Application by Mr E Cattaneo

For Planning Permission for the erection of a garden building

63 Keldgate, Beverley, East Riding of Yorkshire, HU17 8HU

Application No 23/02999/PLF

Date: 28/06/23 Drg. No.: **4090/P9**
 Drawn: DGW
 Scale: 1:5 @ A1

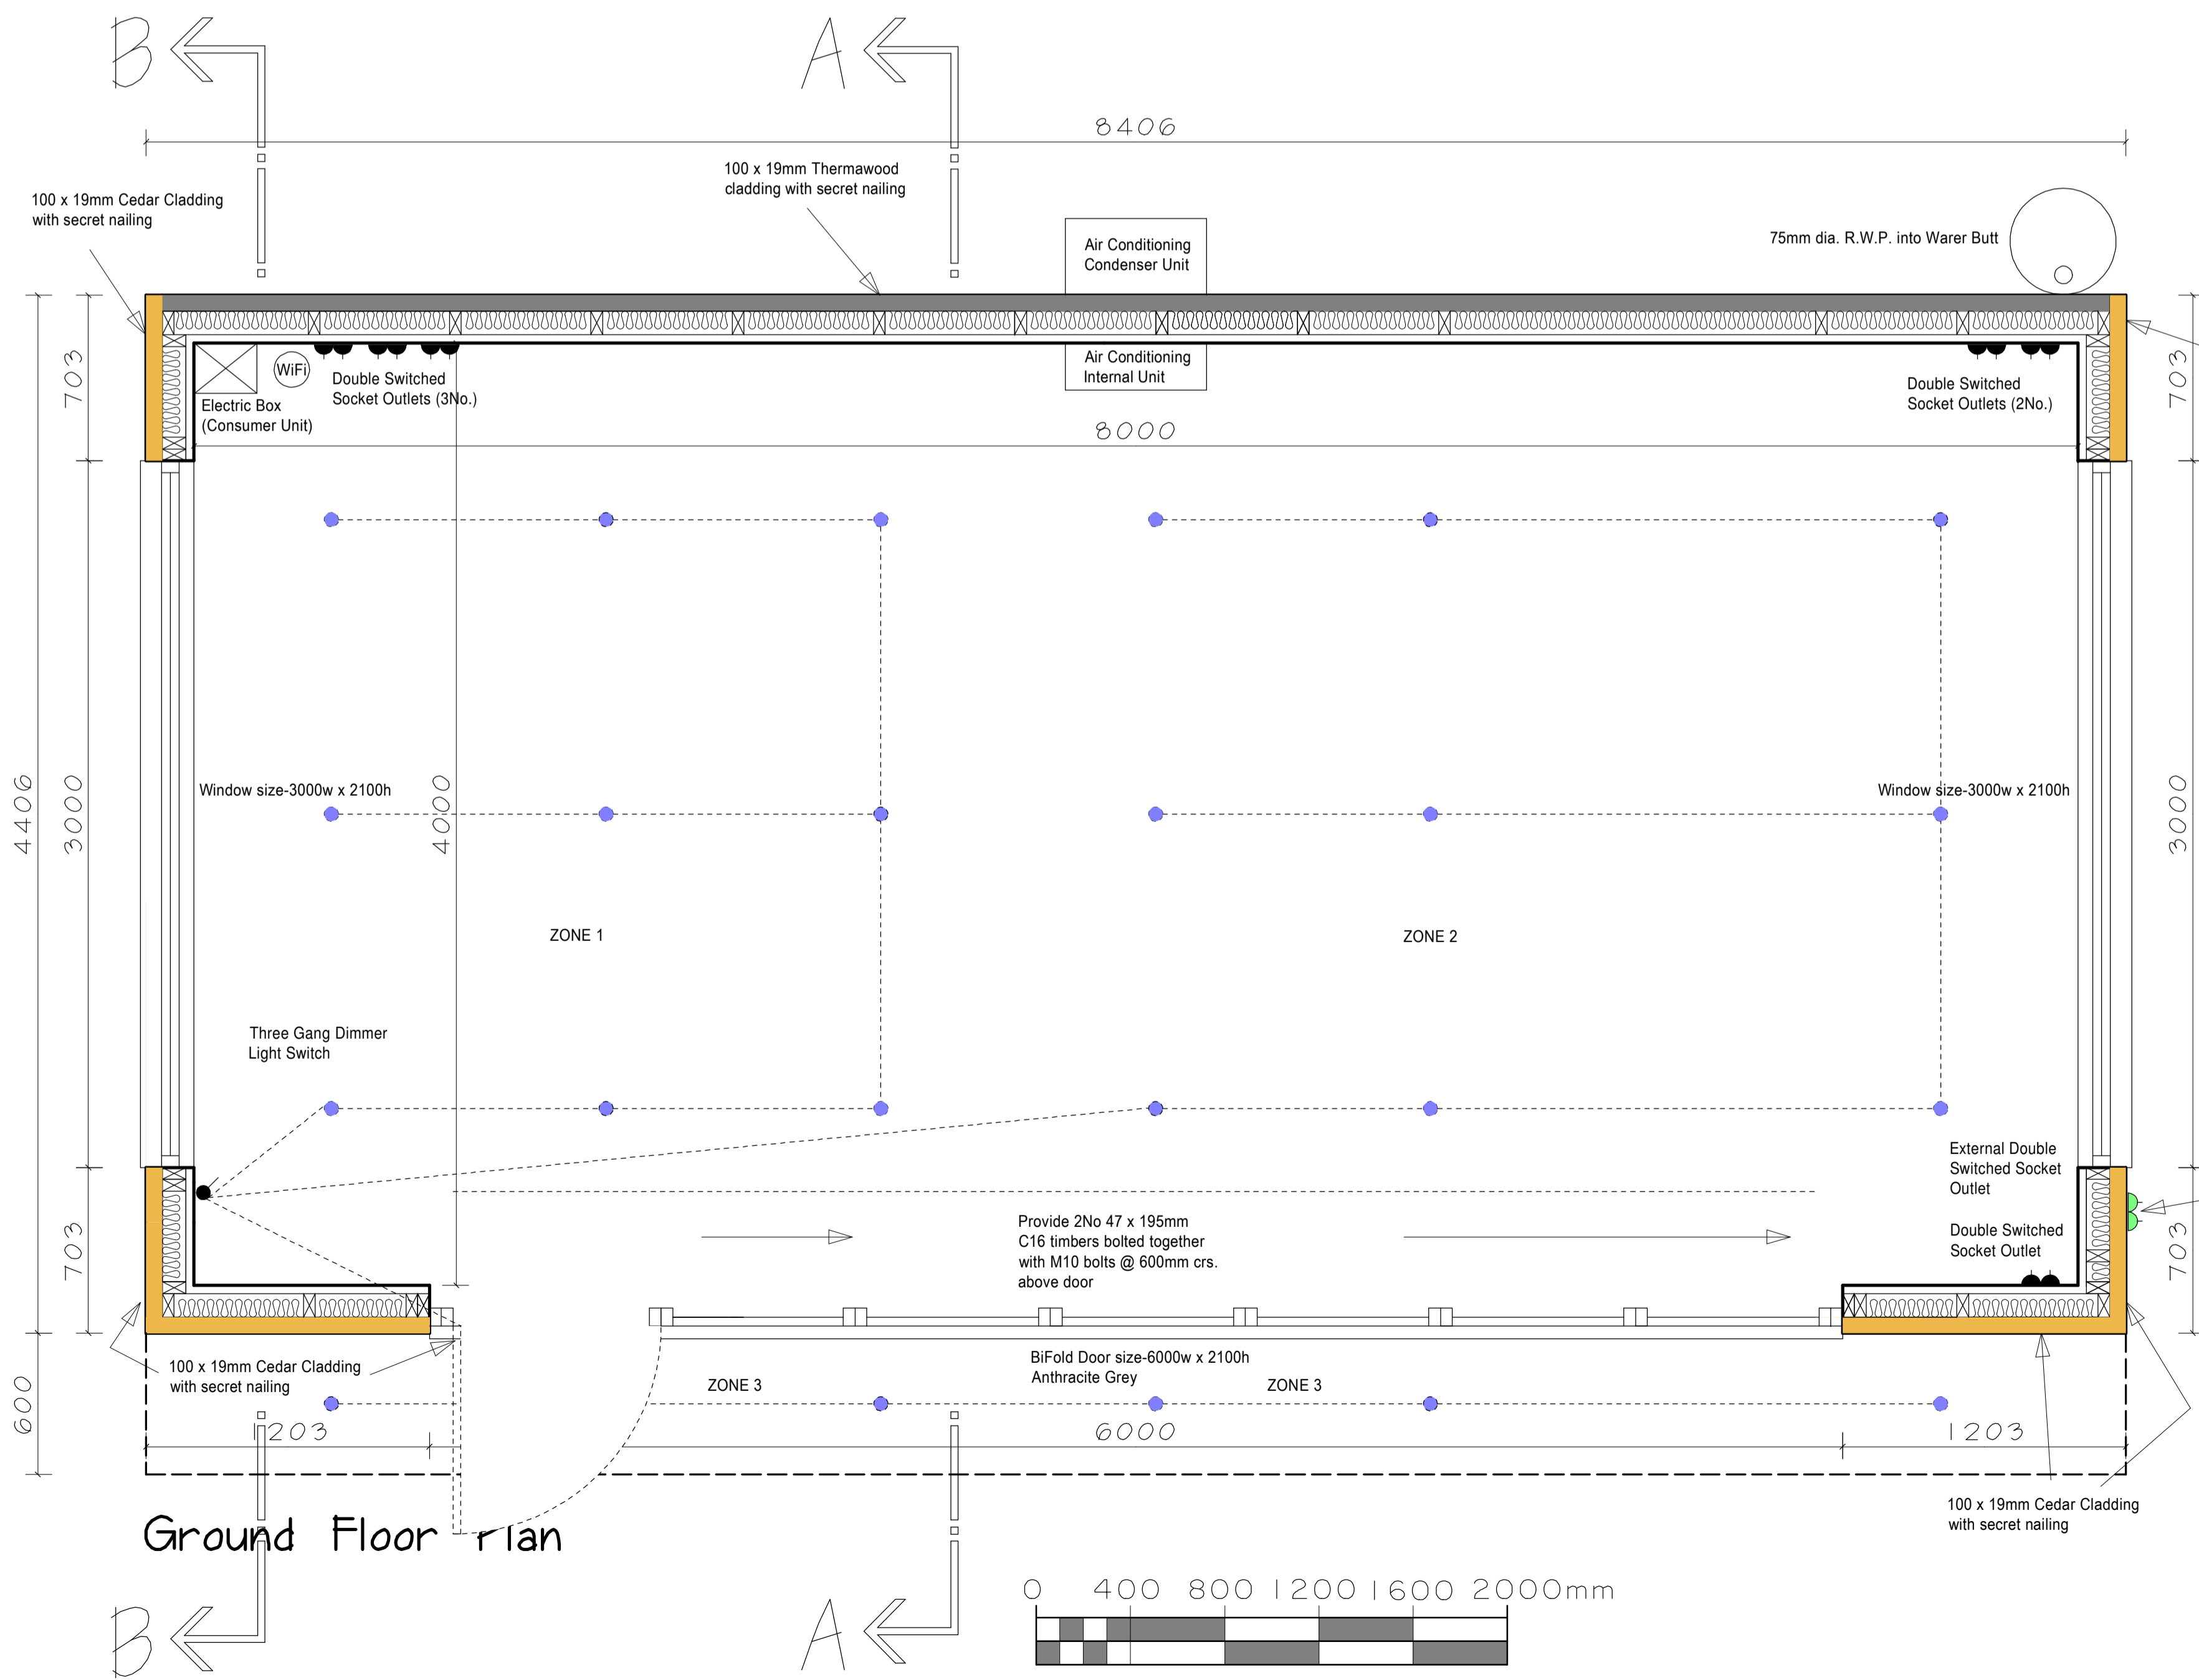
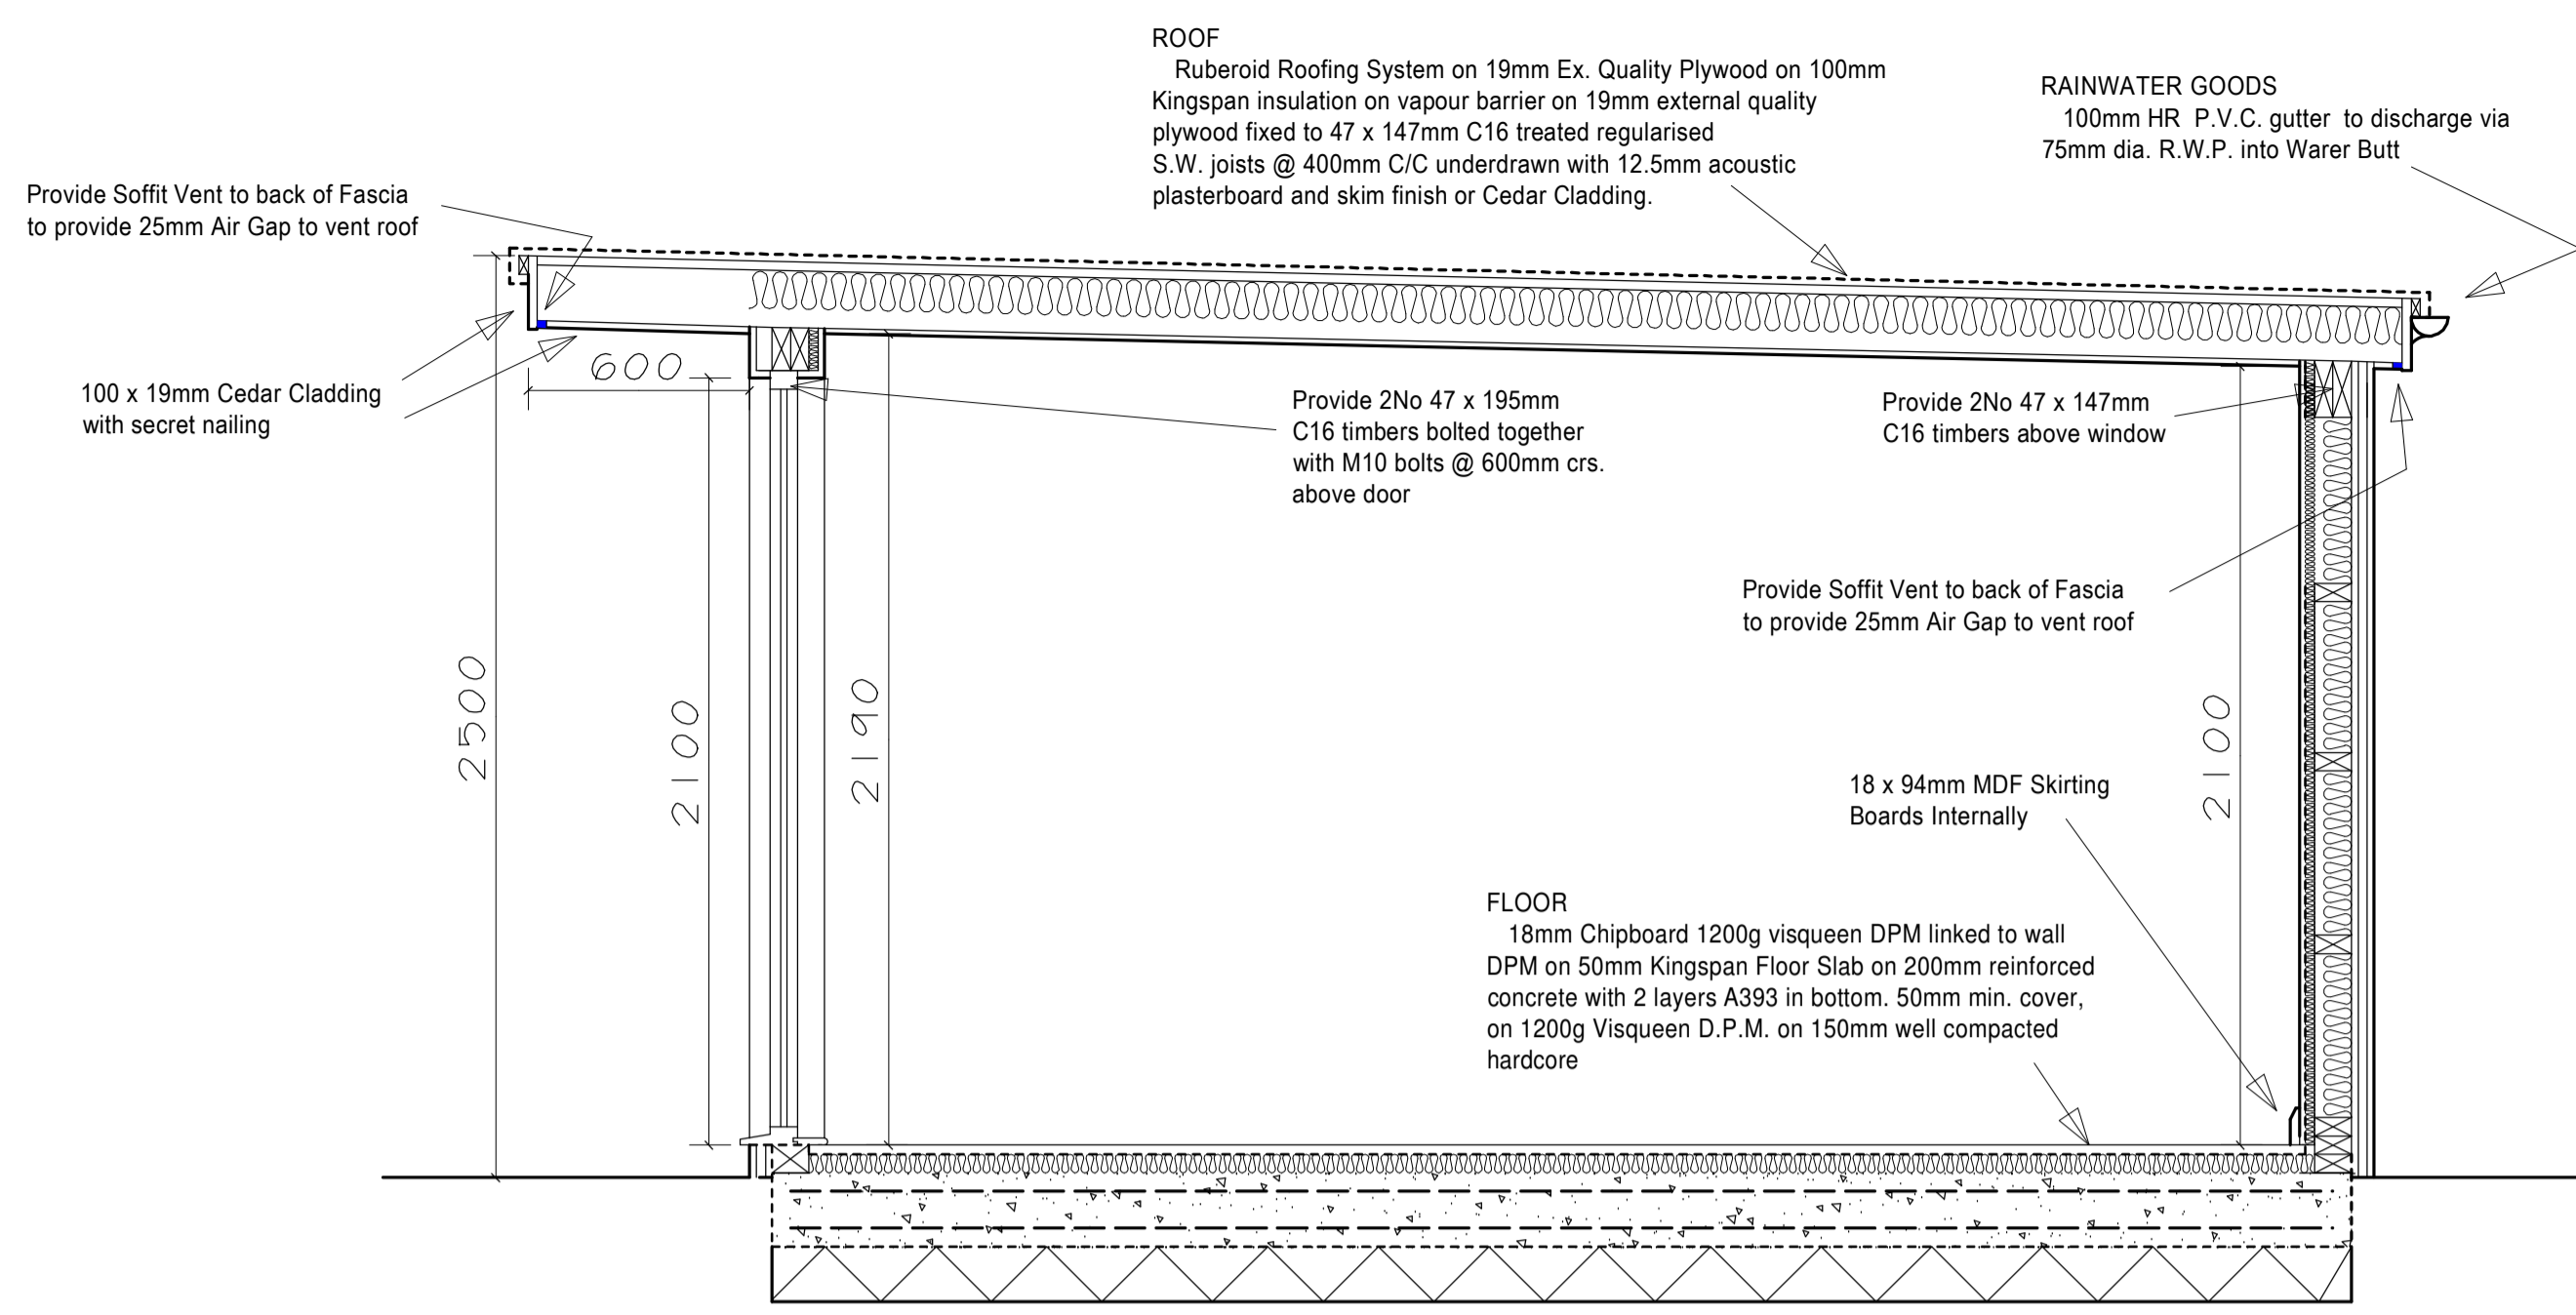
amend and ensure to include the overhang. Please provide an amended Proposed Site Plan as required.	
PROPOSED PLANS (4090/P9) - Please include a scale bar to a scale of 1:50 and 1:20 on the Proposed Plans.	Amended plan submitted
Please provide manufacturers details of the air conditioning unit as shown on the	Attached
LOCATION PLAN - Please note, I have amended the Location Plan to add 'Keldgate' to the road in front of the property.	Noted. However, the location plan was provided by the Planning Portal
